Addendum No. 1

RE: Contract # C204571

Columbus County (R-5797)

DRAINAGE, GRADING, PAVING, AND STRUCTURE ON US-74 AT SR-1506

DMS-1 & CCTV-1 AND DMS-2		SEAL
	DIVISION 06 COLUMBUS CO BOARDMAN		
750 N. Greenfield Pkwy., Garner, NC 27529	PLAN DATE: APRIL 2021	REVIEWED BY: A. J. SKUCE	DATE: 4/12/2021
SCALE: 0 N/A	PREPARED BY: L. E. NEAL	REVIEWED BY:	INIT. DATE
CADD Filename:

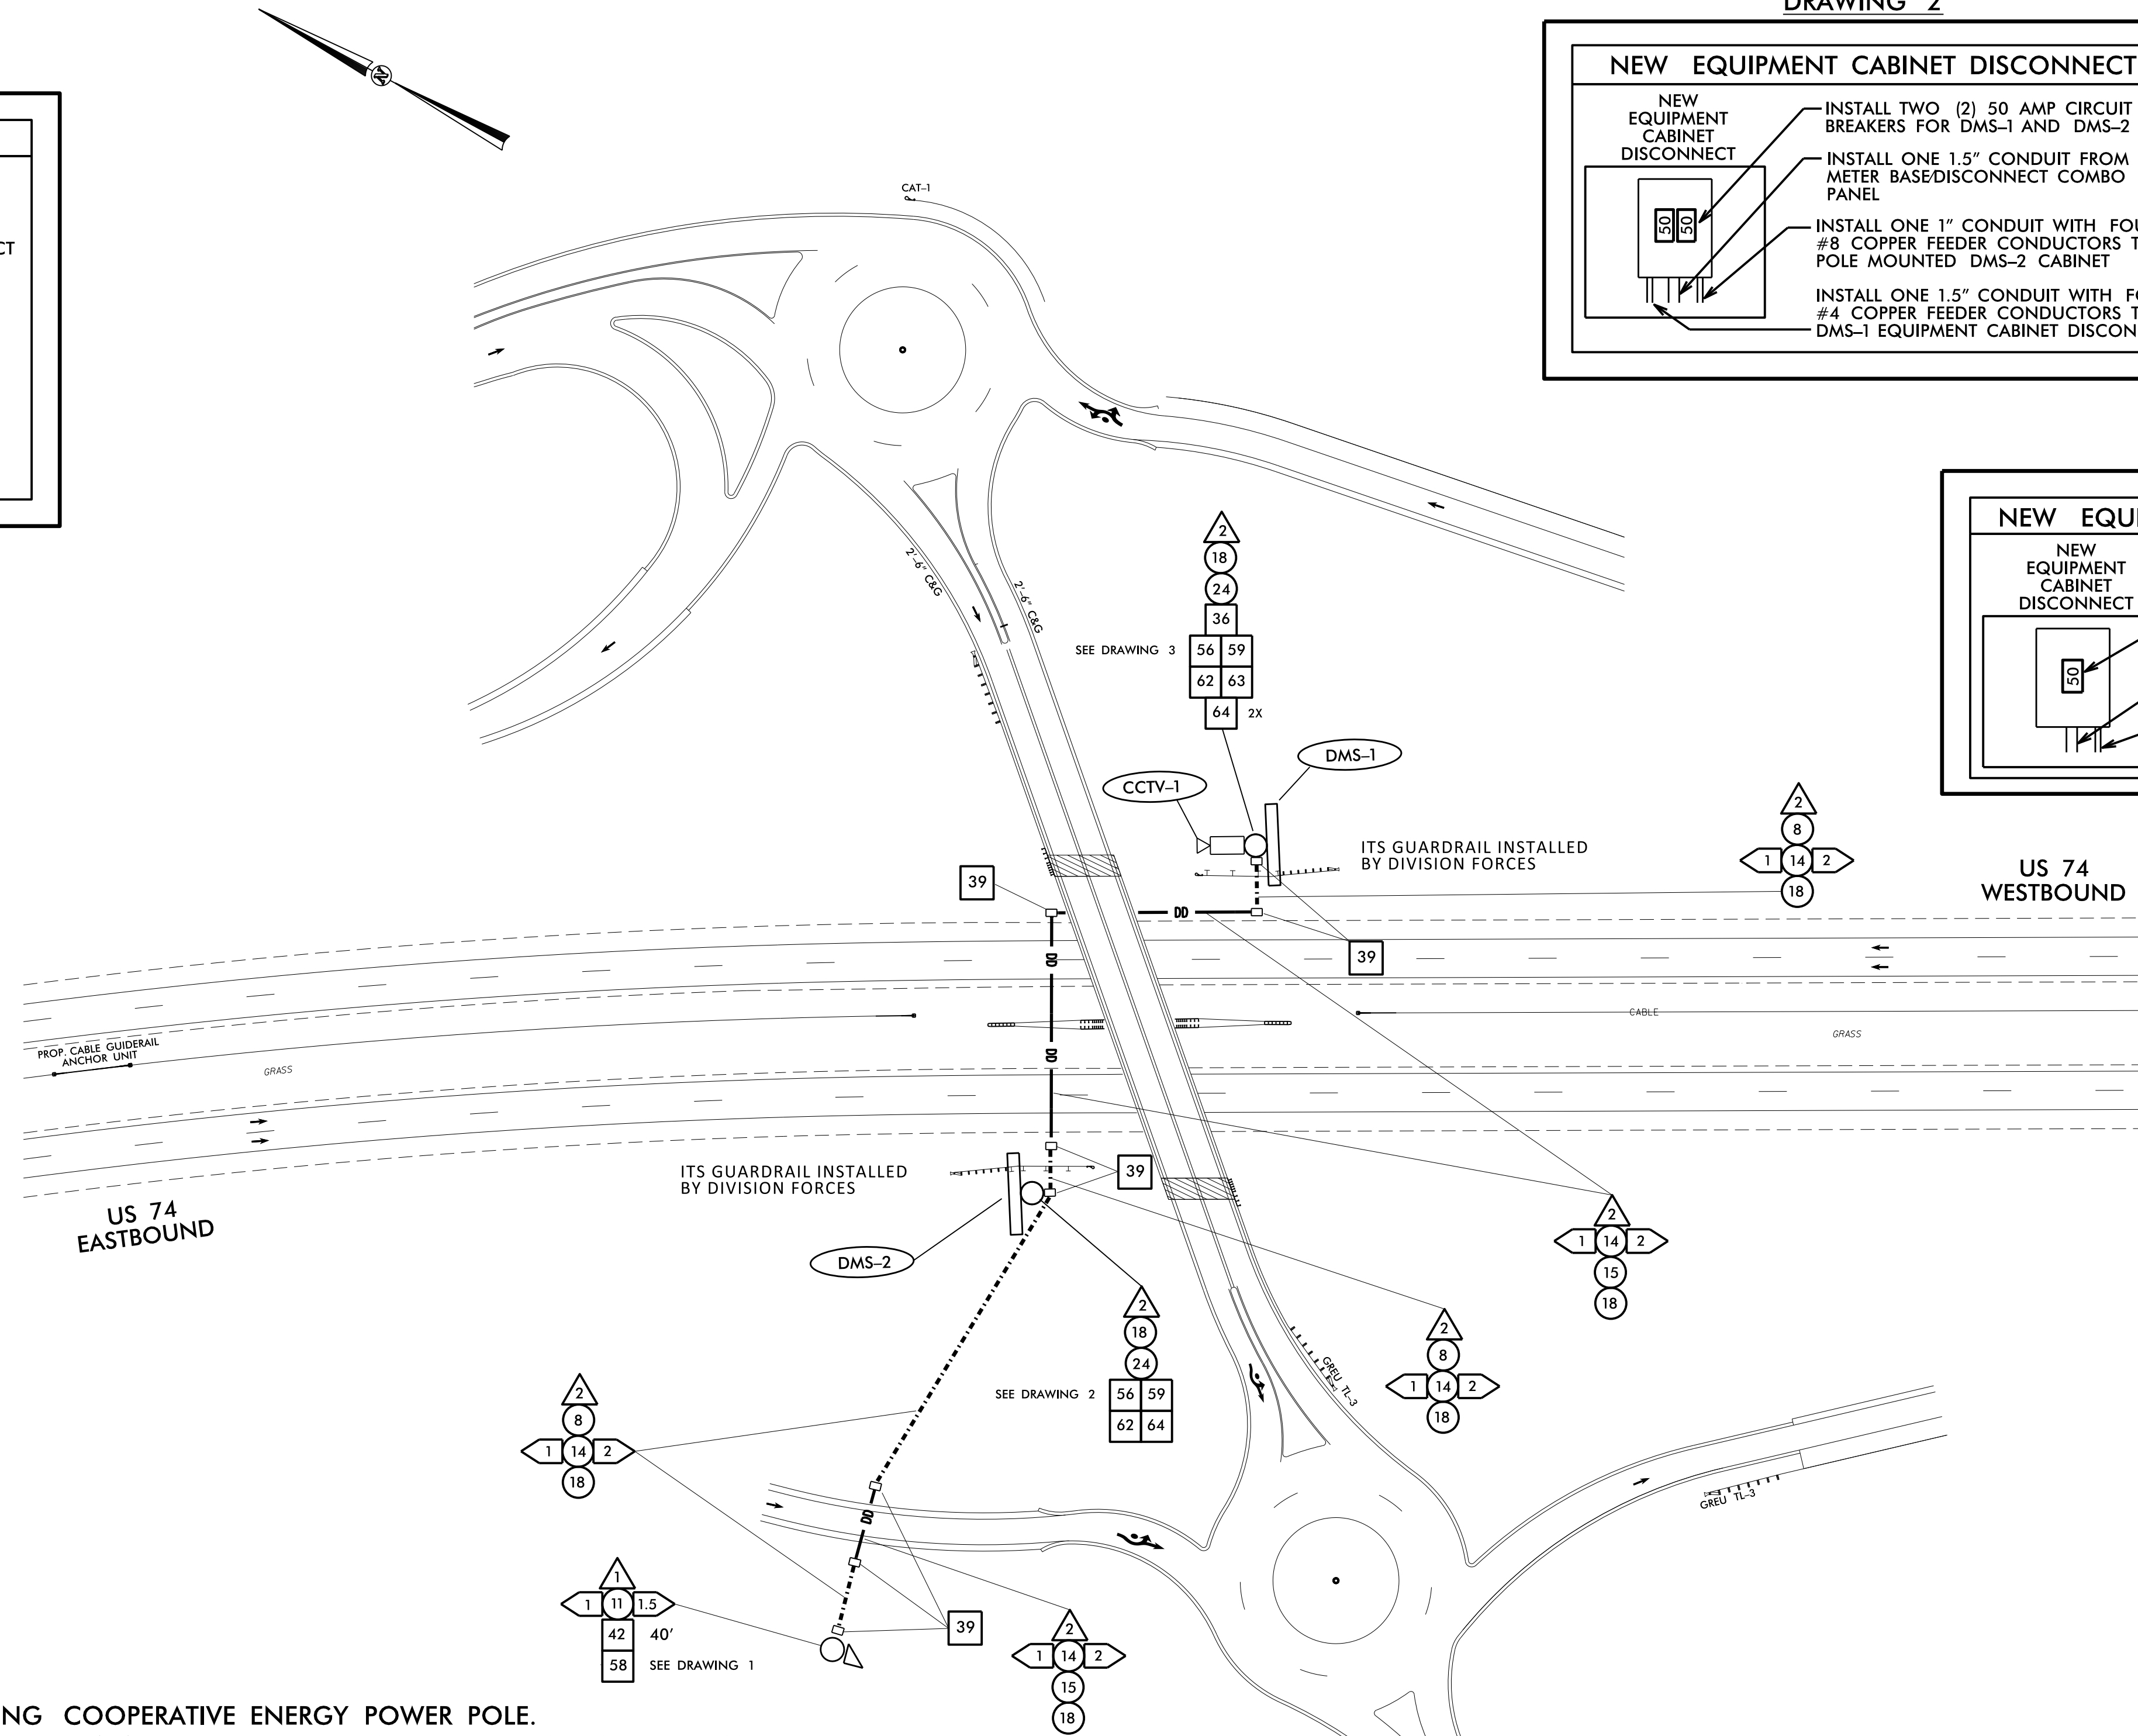
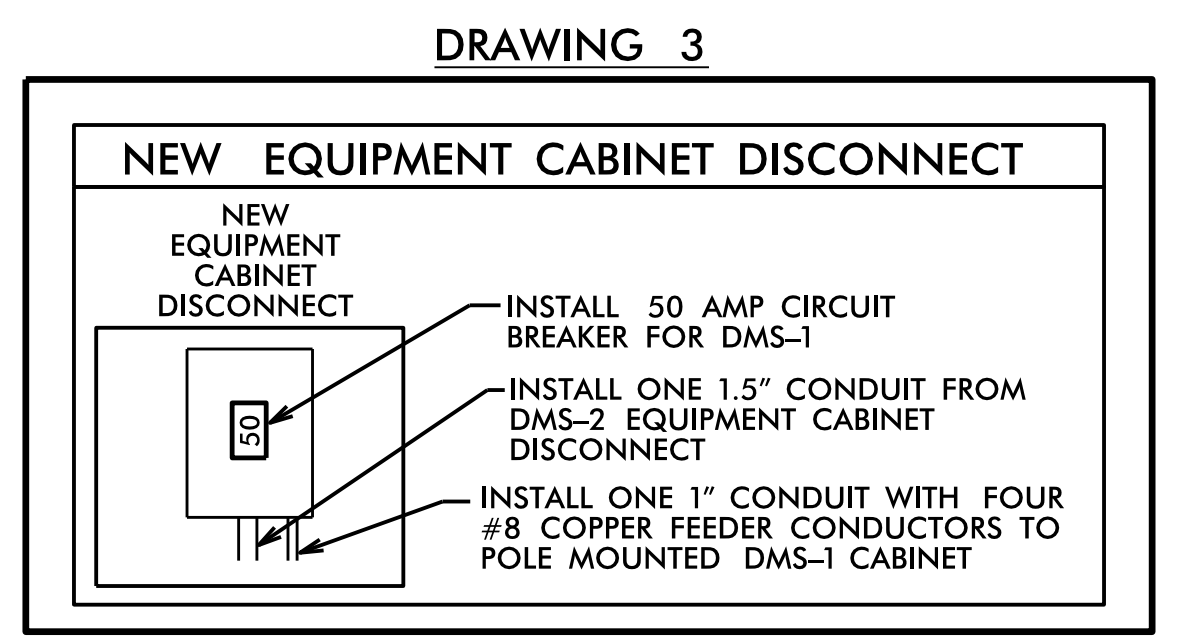
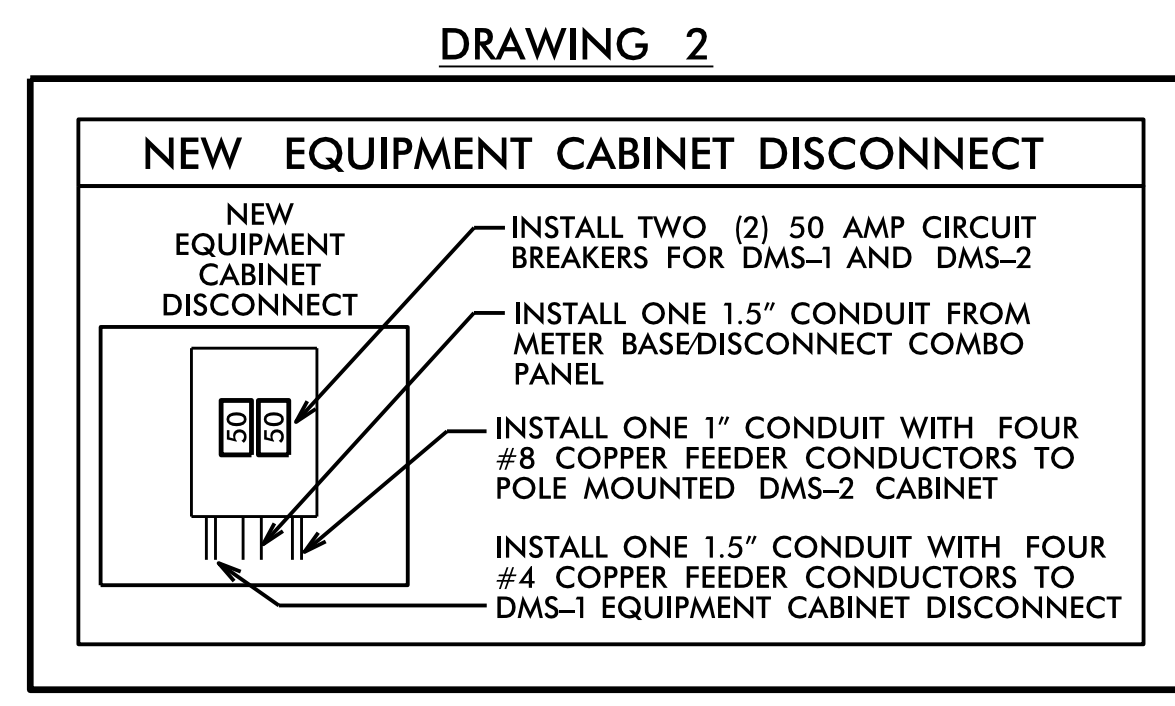
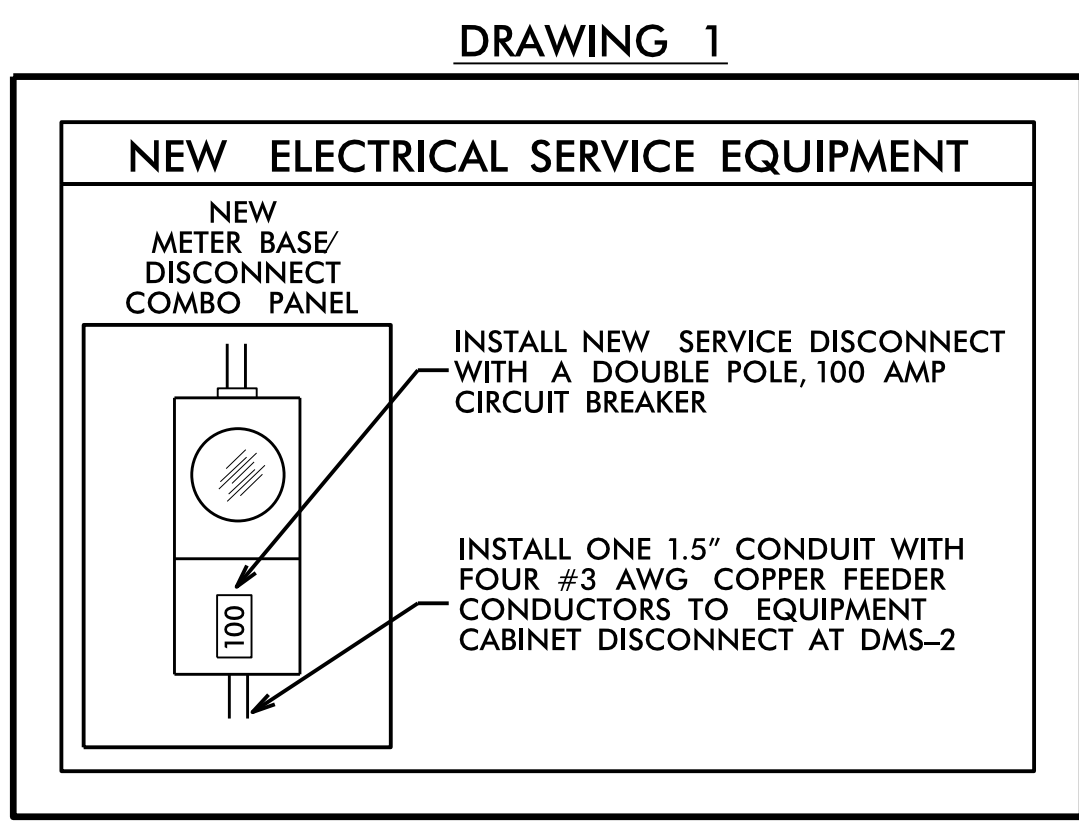
Sheet No.	Revision
ITS-3	Change to the "Construction Note Symbology". Number of Riser(s)Conduit(s) from "2" to "1".
